From: Liz Annalls [REDACTED]
Sent: 17 June 2020 11:46
To: Planning.Responses <Planning.Responses@arun.gov.uk>
Subject: RE: Planning Consultation on: A/76/20/PL

App No: A/76/20/PL
Address: Land at Dapers Lane Angmering
Proposal: 84 No. dwellings, public open space, play areas, associated infrastructure & landscaping. This application affects a Right of Way.

Outstanding information still required 17.06.2020

A109012 LA100-106[A].dwg

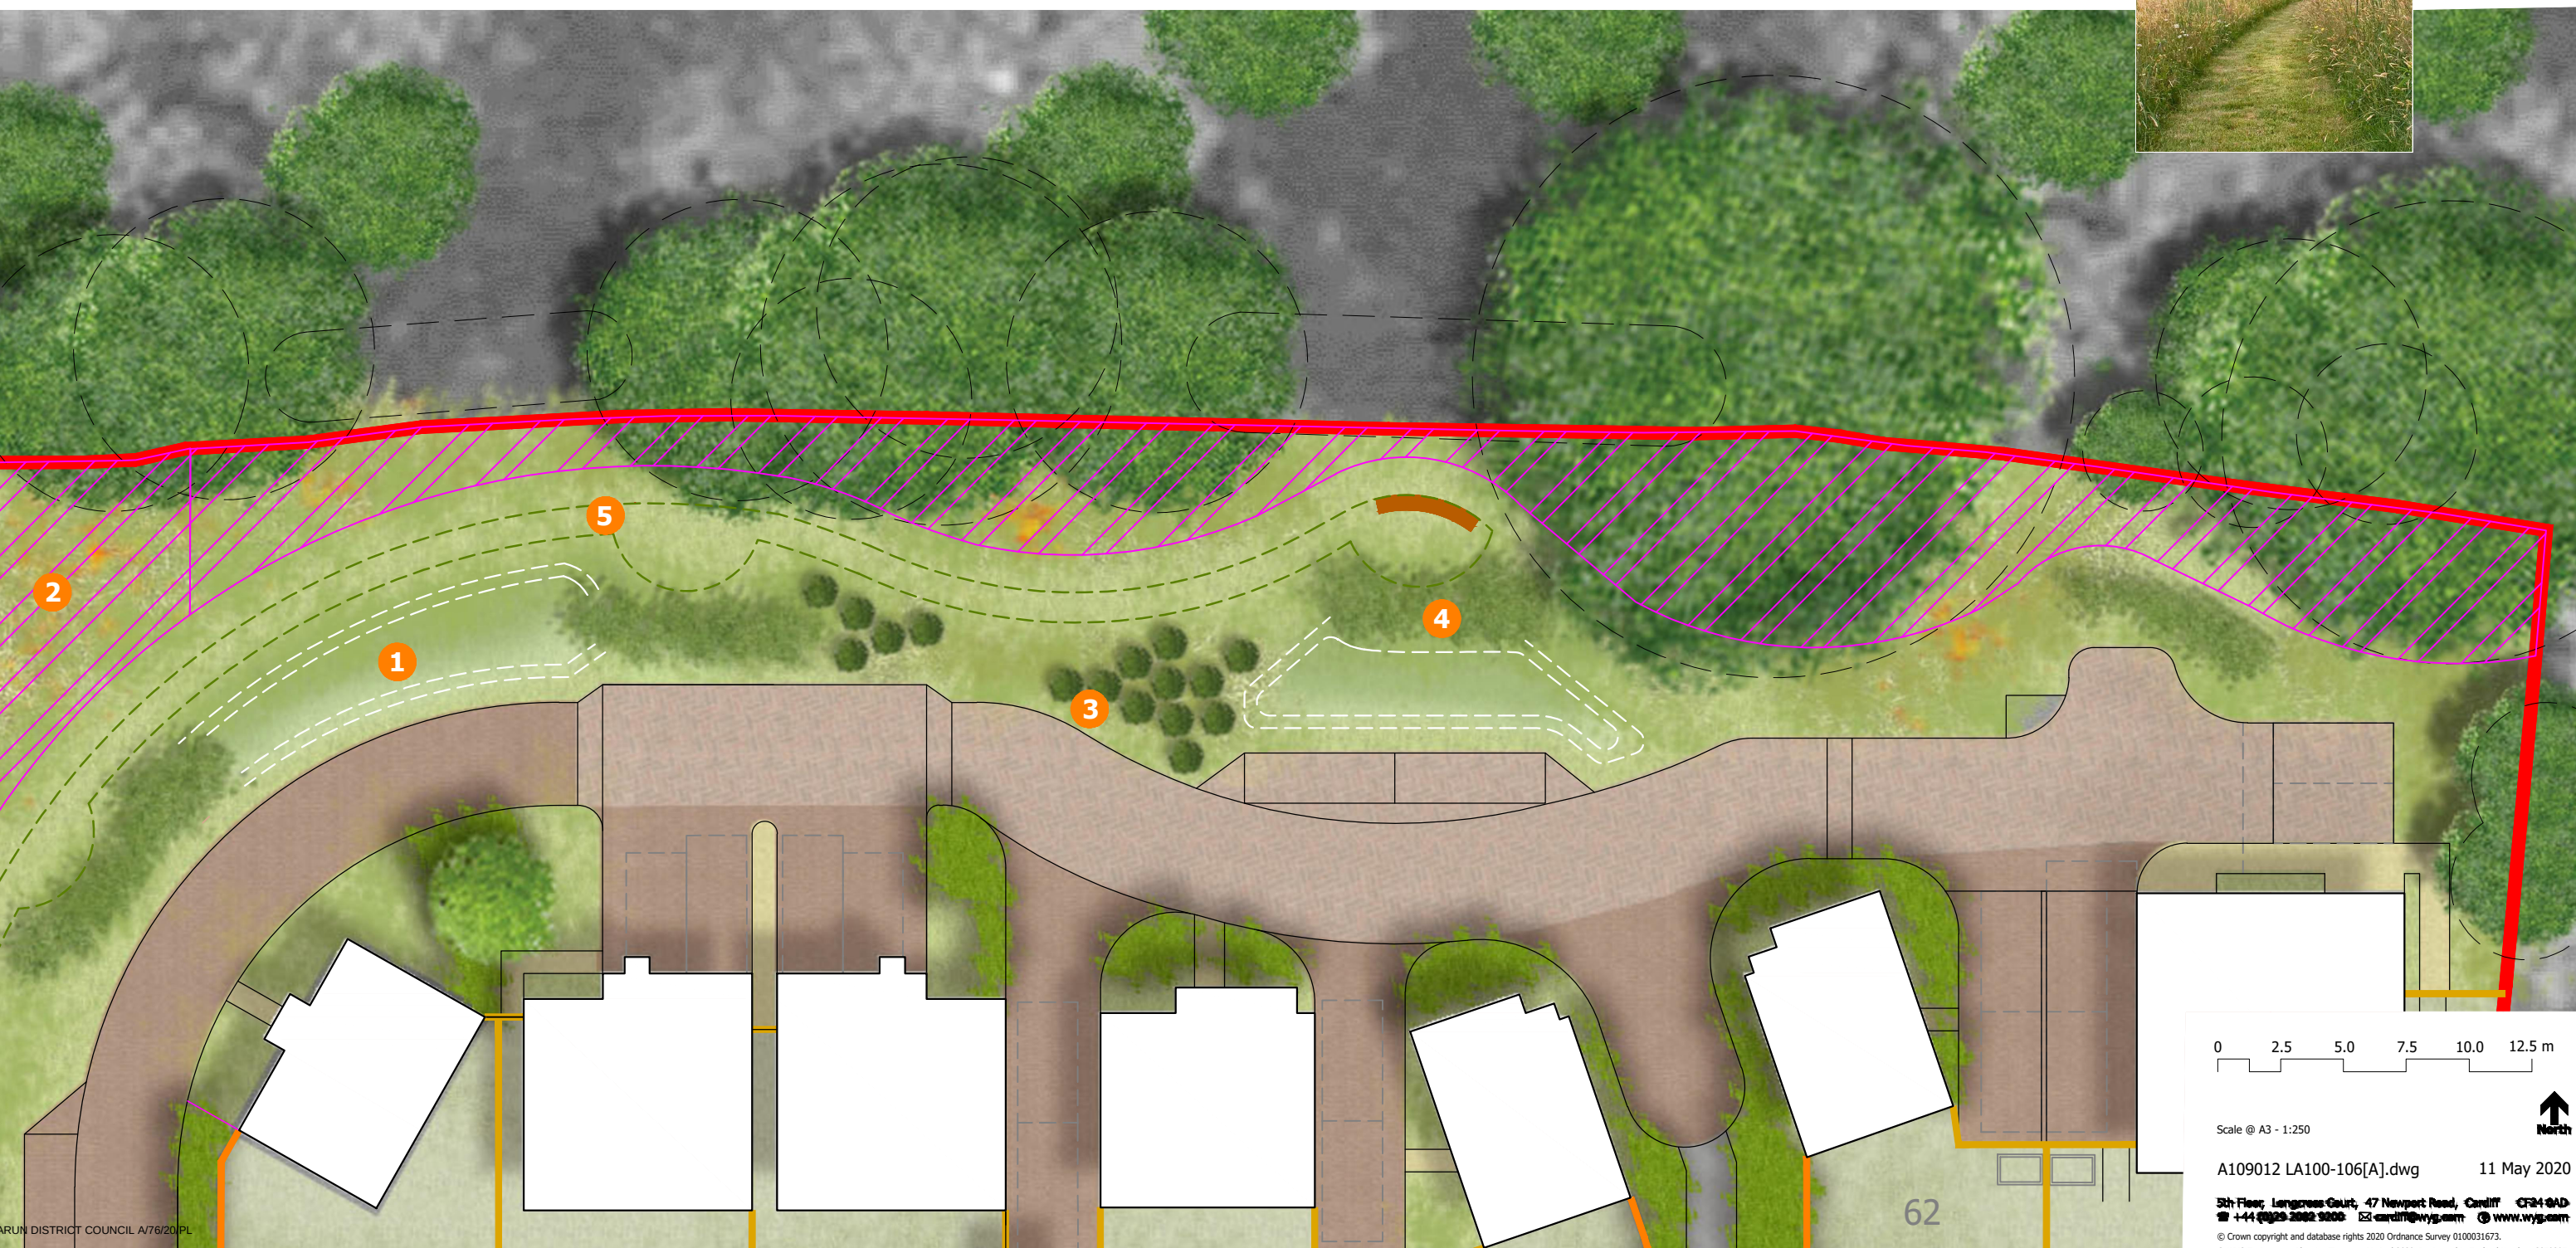
As detailed within the Dormouse Survey report (Feb 2019) dormouse have been found to be nesting and foraging within the hedgerows onsite. Due to this mitigation is required along with a Protected Species License from Natural England. Unfortunately very little information has been provided relating to this mitigation. We require that prior to determination a mitigation strategy is submitted detailing the timings of the works, retention of areas, methodology of the works, enhancements and post development monitoring and safeguarding.
